MEMORANDUM

RE: Traffic Memorandum for Falcon Marketplace, Lot 6
El Paso County, Colorado

LANDSCAPE PLAN

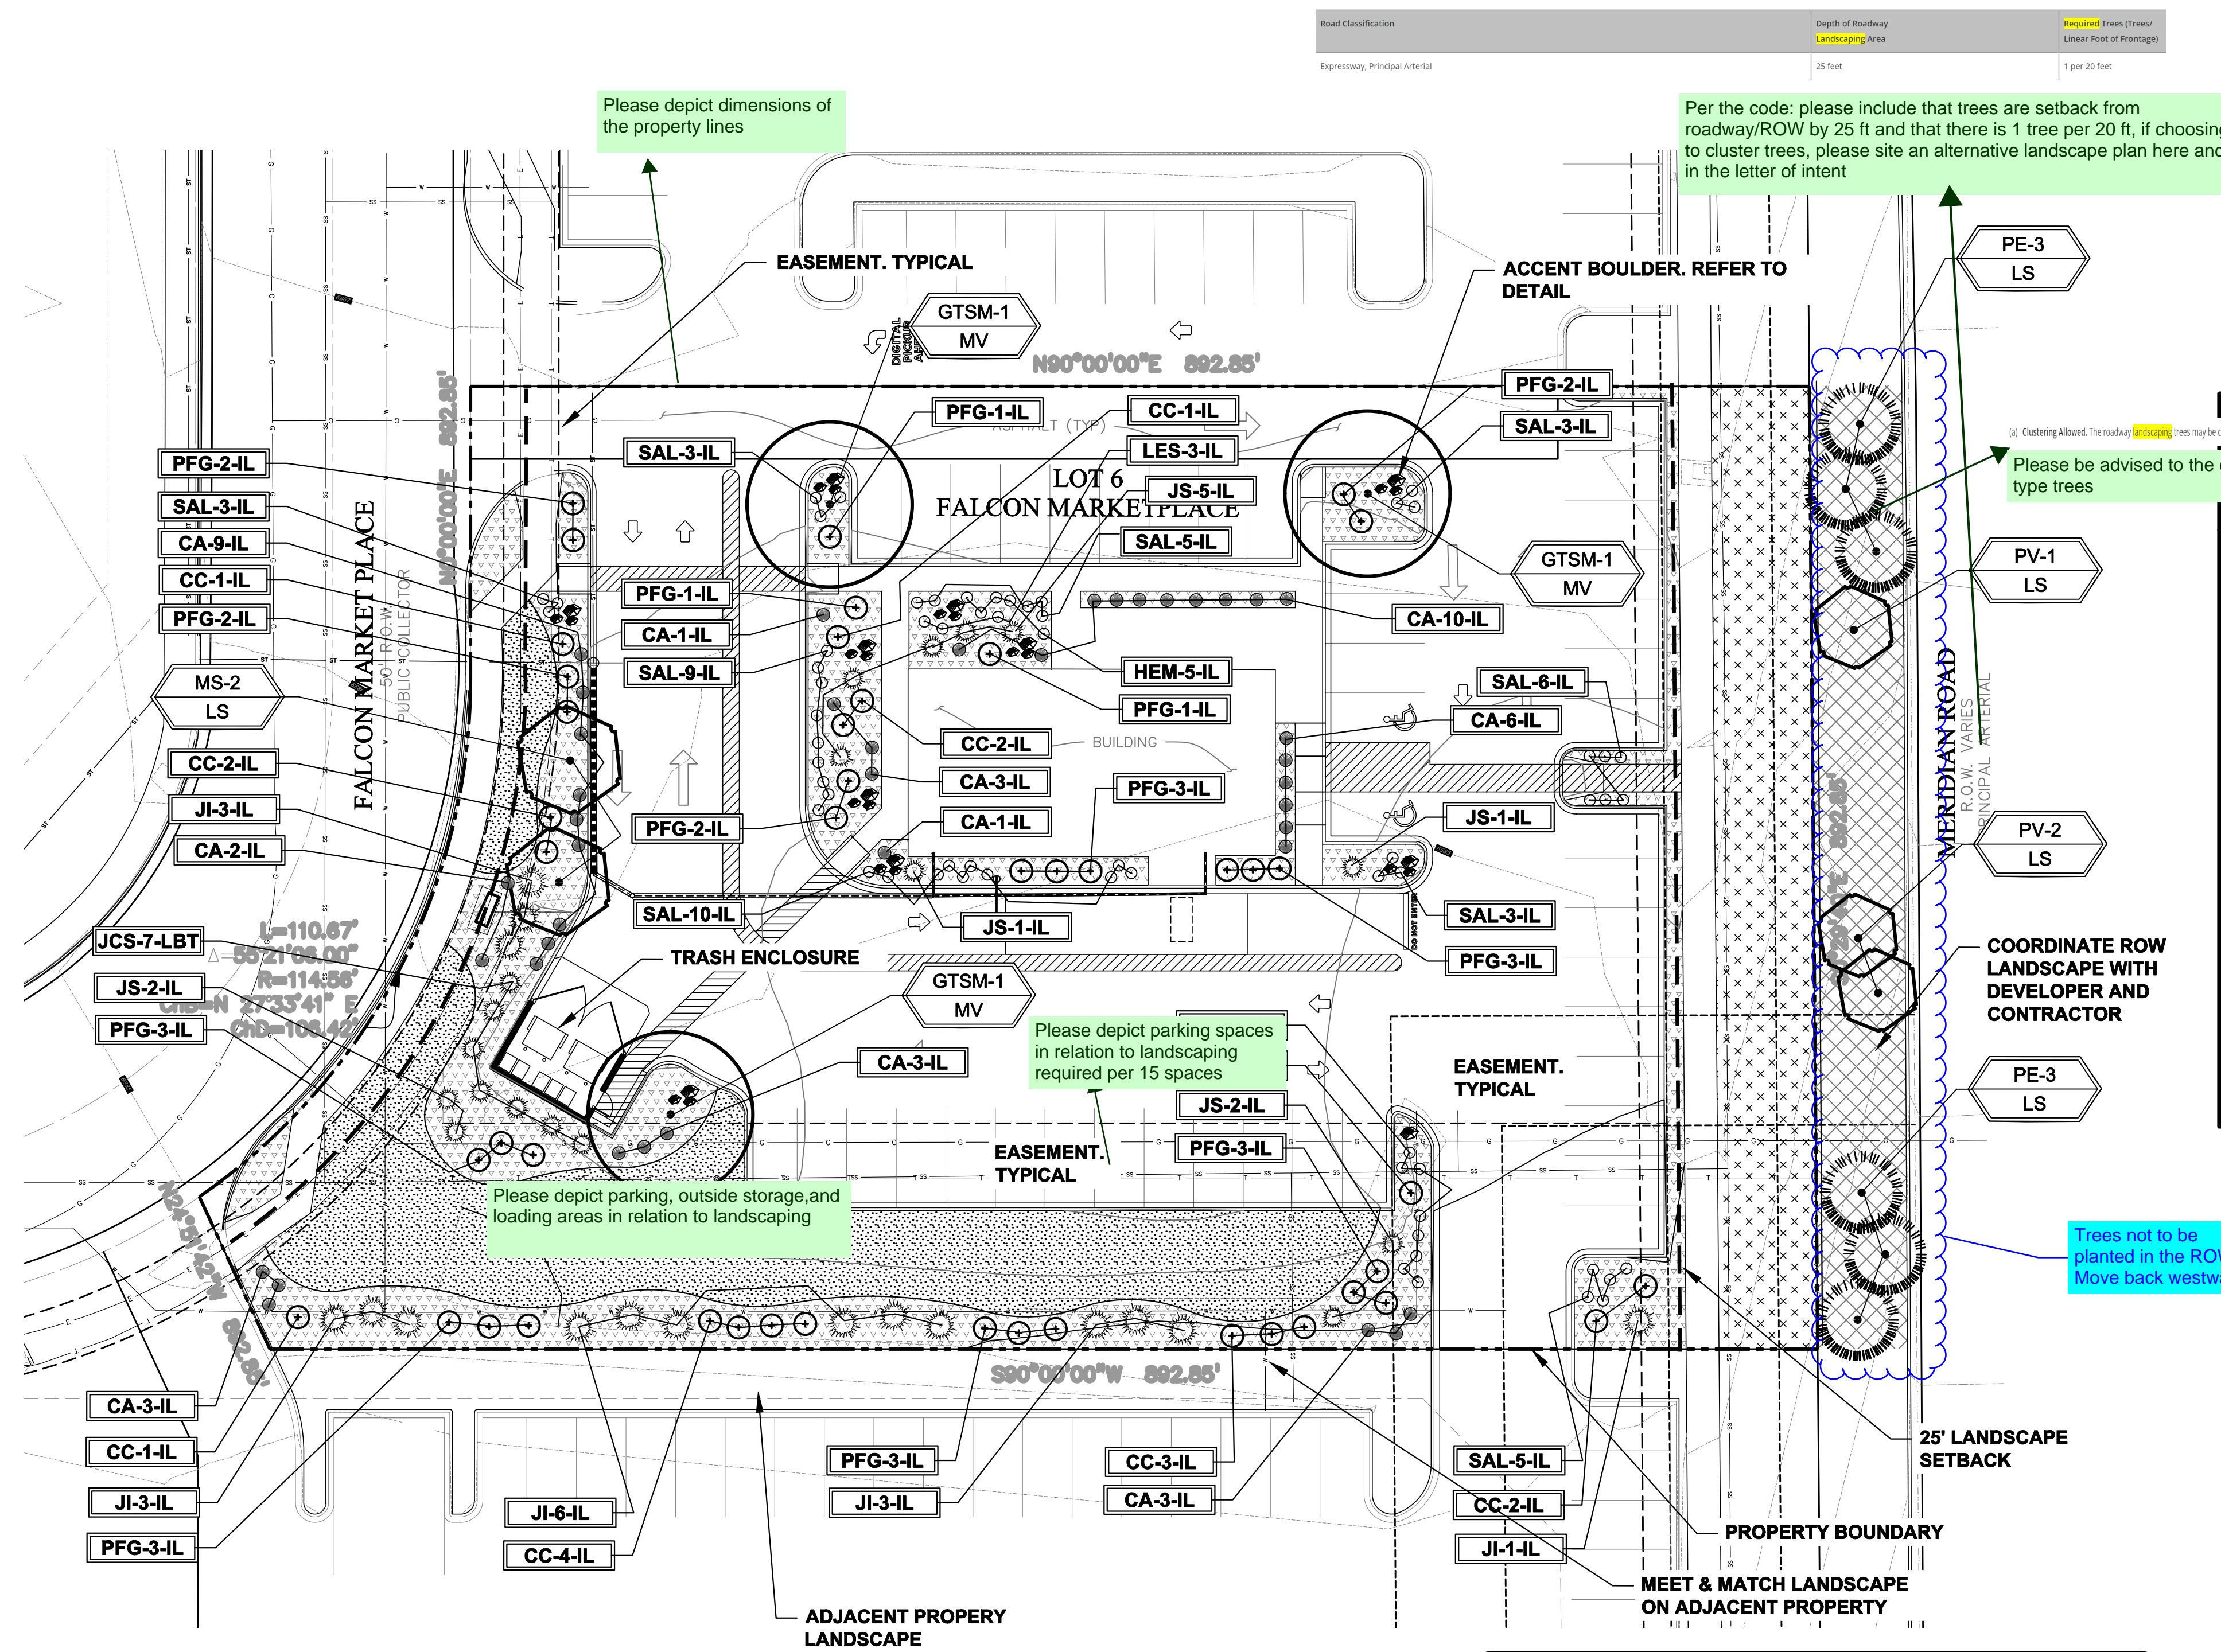
Provide complete circulation plan to ensure drive-through traffic will not back up into public right of way and shared driveway between lot #5. Entrance direction to drive through may need to be moved to east side of lot. See site plan
